# CITY OF ALBUQUERQUE

October 23, 2018

RE: **Oso Bio Syringe Line**  
**4401 Alexander Blvd NE**  
**Grading and Drainage Plan for Building Permit**  
**Engineer's Stamp Date 10/16/2018 Disapproved**  
**Hydrology File: F16D003B1**

POND VOLUME= 106359 CF (2.44 AC. FT)

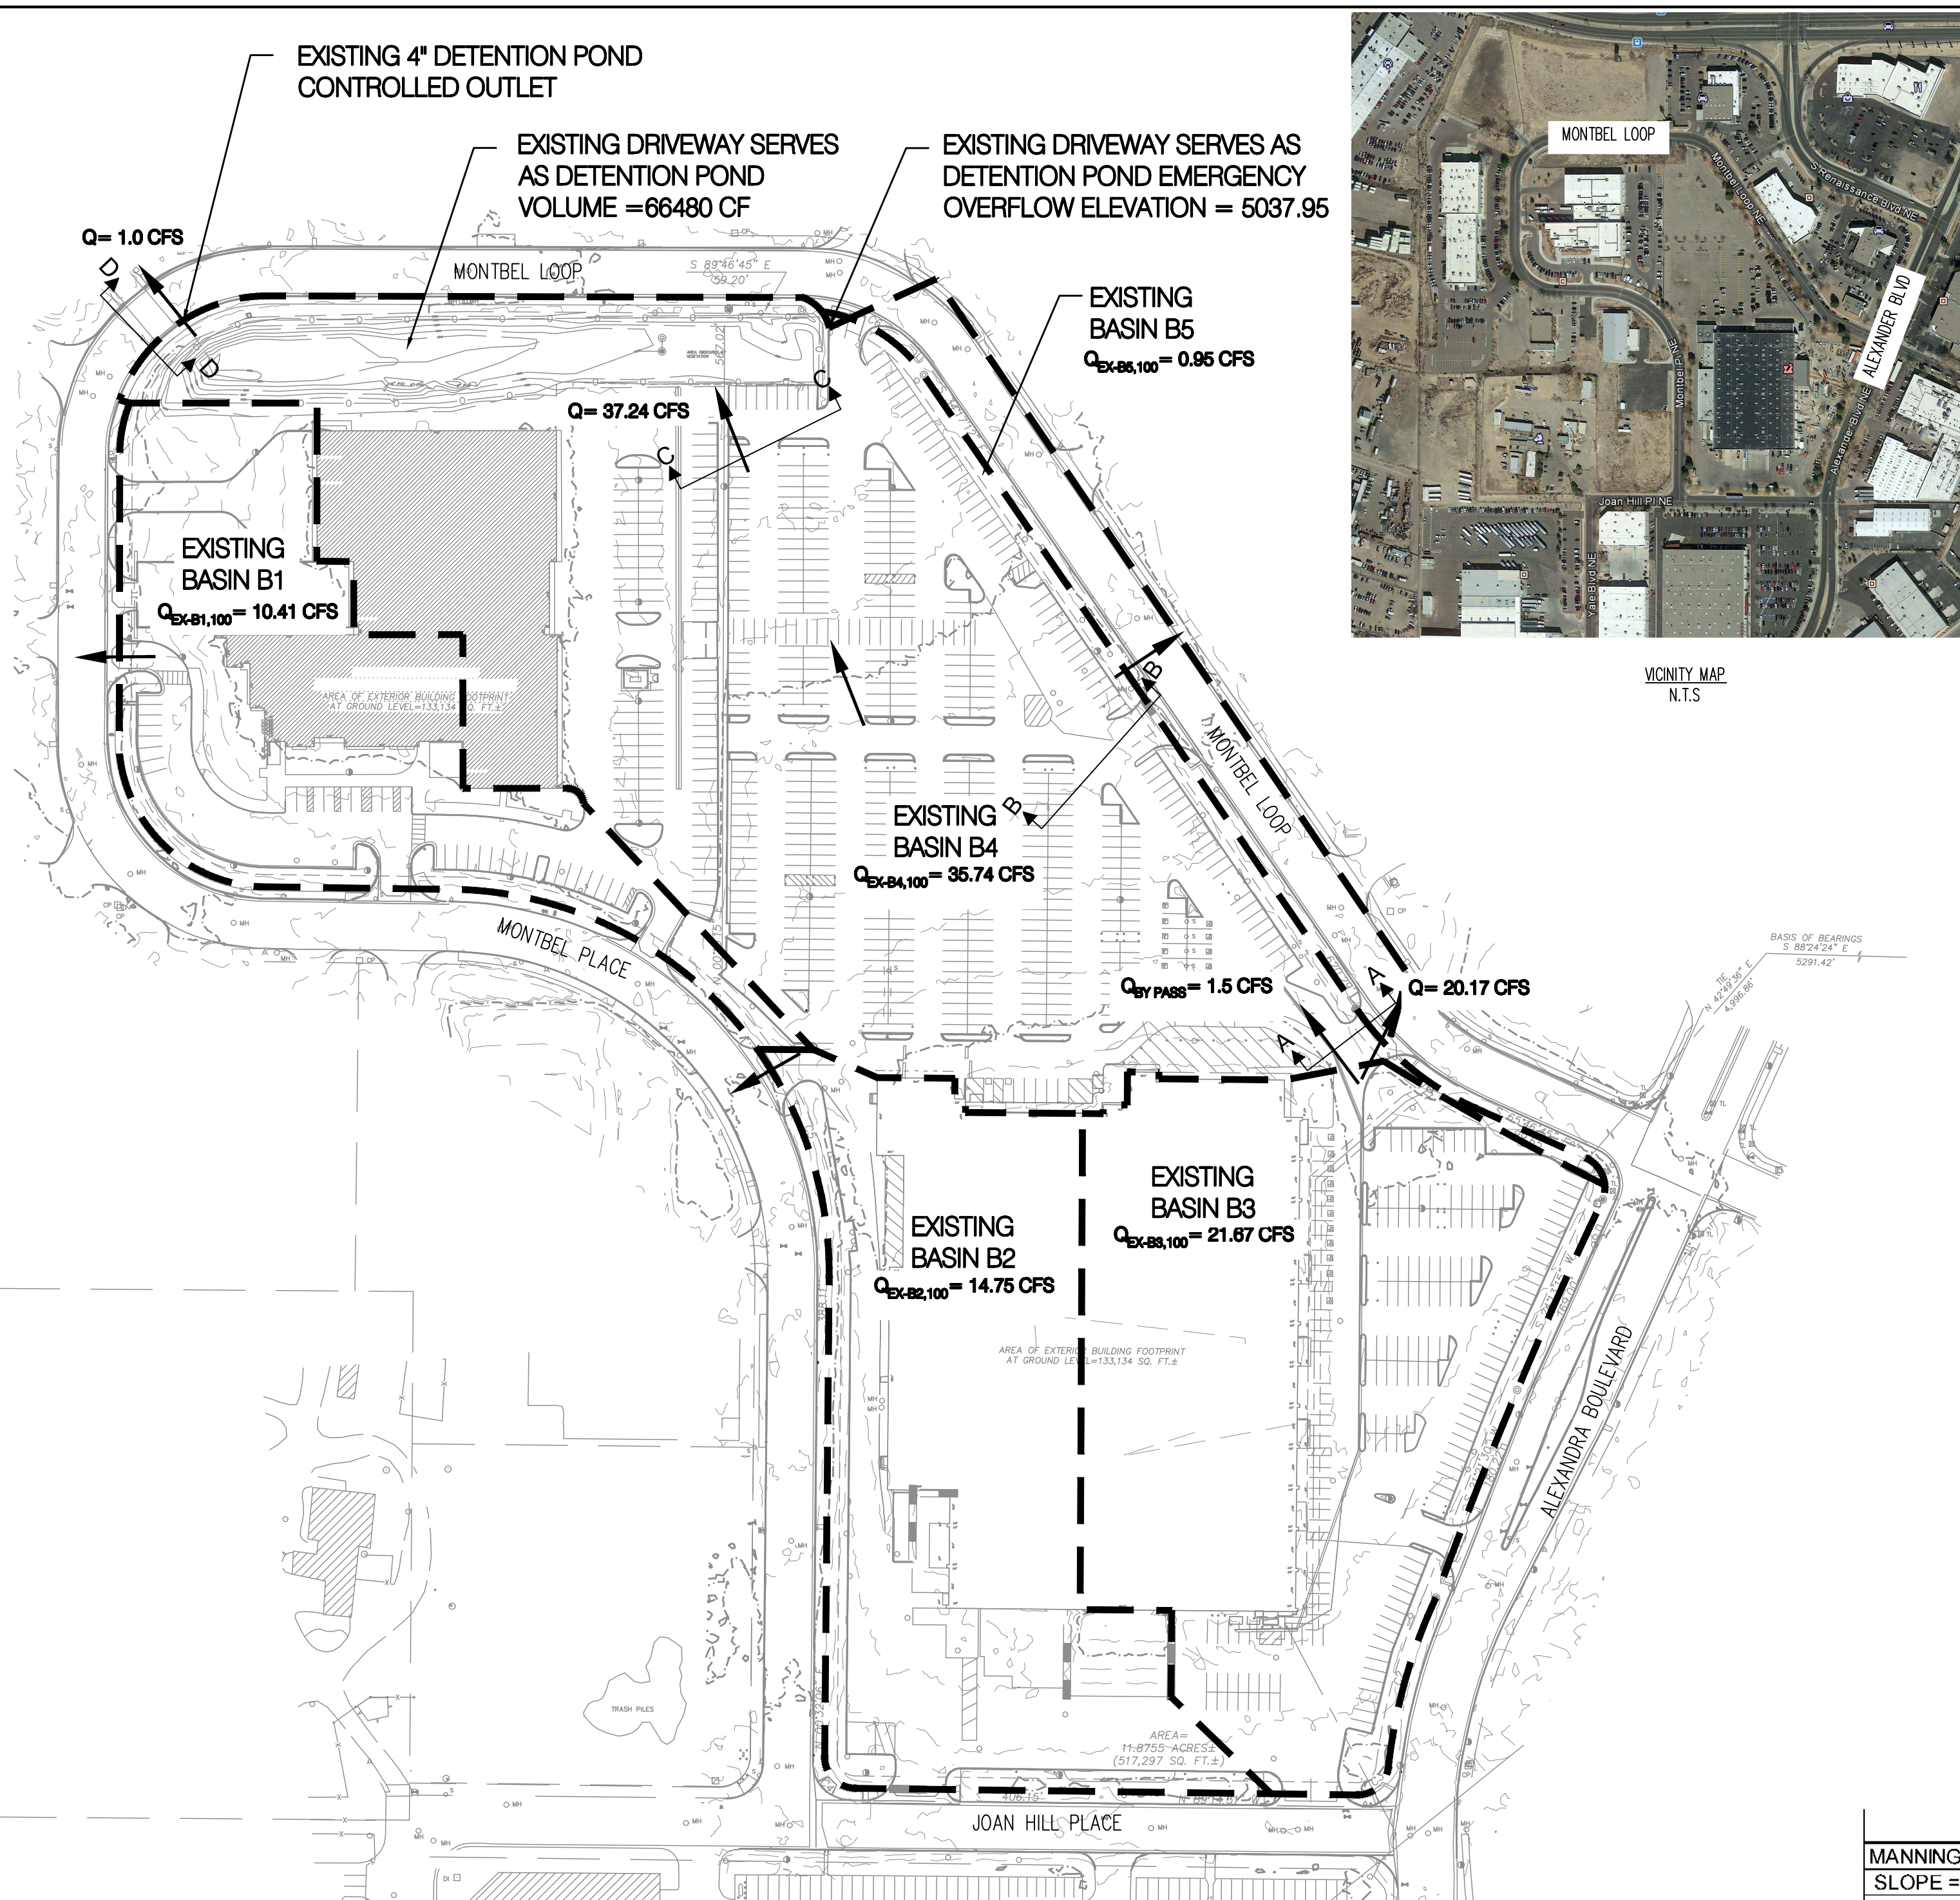
6. Specify a grate to prevent clogging of the outfall pipes to be placed over the entire headwall/wingwalls of the outlet structure.
7. Exhibit 'A' to the drainage covenant needs to include the entire pond and its emergency spillway; the east side of the pond and the spillway are missing. The drainage covenant must be signed by the "owner" of the property that the pond is located on, Tract A. If a separate agreement between the two property owners, Tract A and Tract B, is required by the owner of Tract A, the City does not need to be a party to that agreement. The owner's signatures must be notarized and the original document together with a \$25 check payable to the Bernalillo County must be submitted to Madeline Carruthers on the 4<sup>th</sup> floor.

**PROPOSED DRAINAGE MANAGEMENT PLAN**

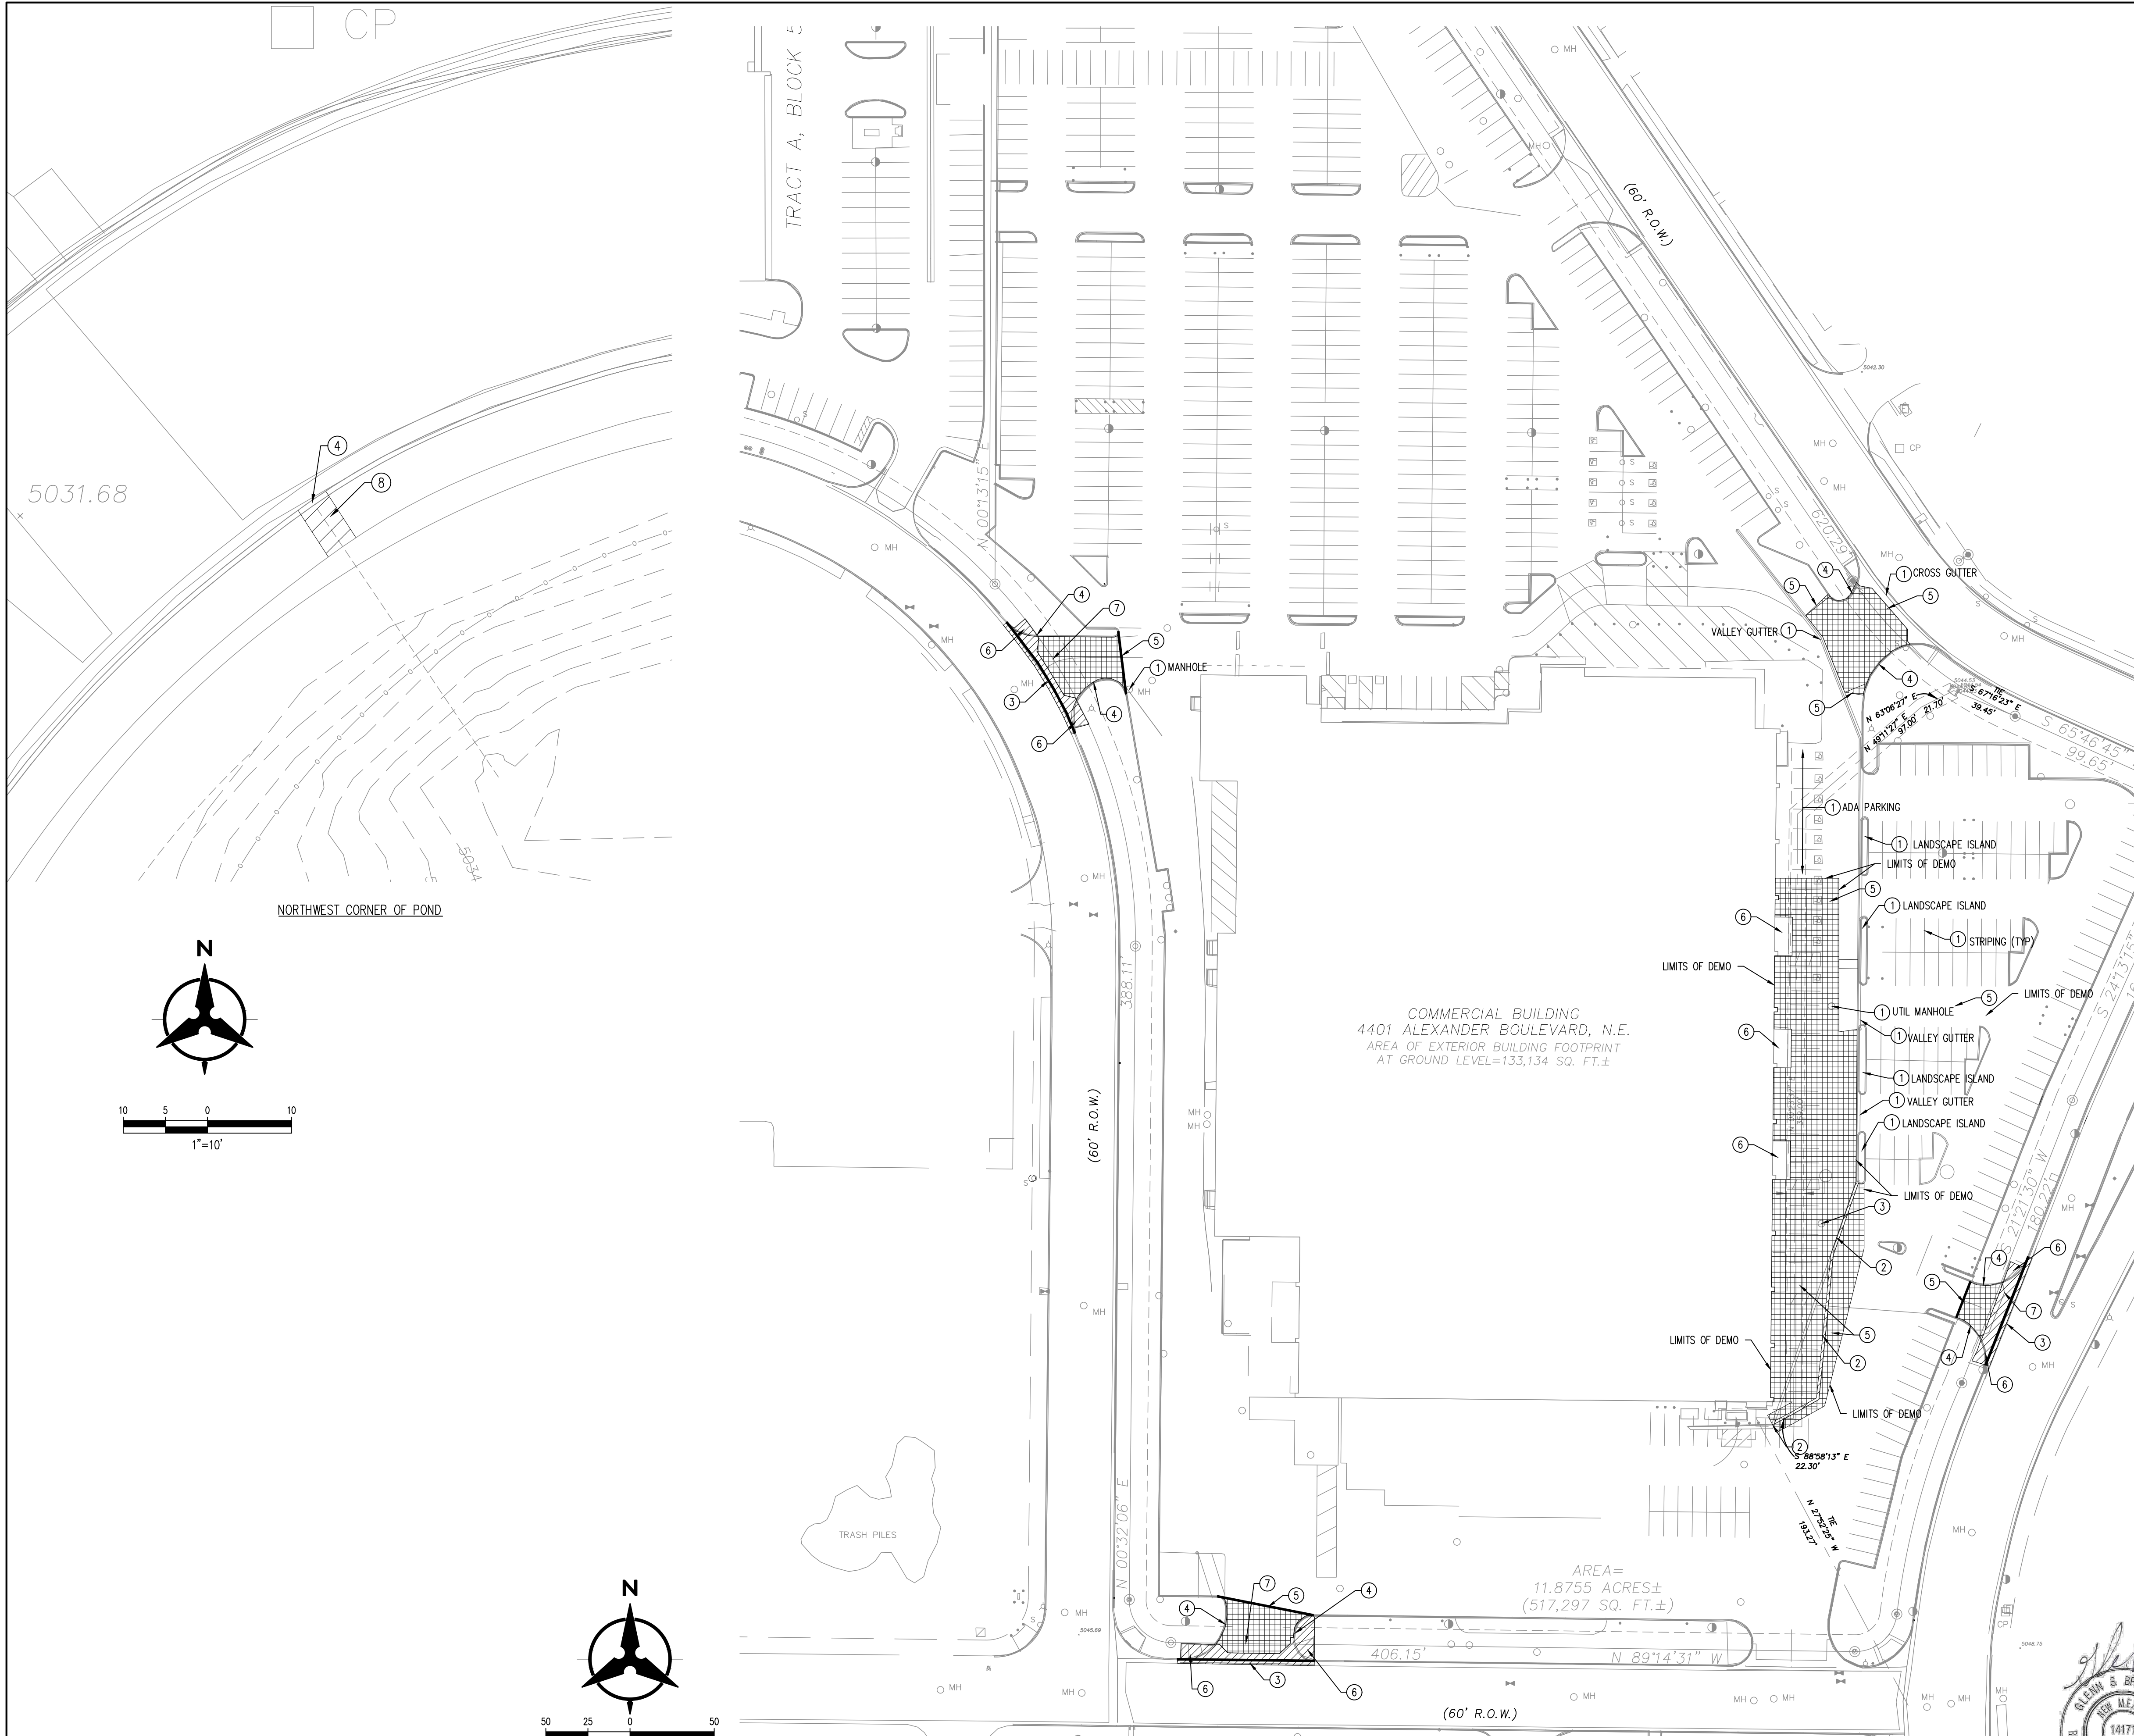
4. Provide detailed survey and spillway capacity calculations of the emergency spillway/driveway and along the top of berm. It appears that the top of berm is ~5038' and the spillway/driveway overflows at 5037.95'. Per Transportation's comments on the TCL, this driveway needs to be closed. So a new emergency spillway will need to be specified, complete with capacity calculations and freeboard.
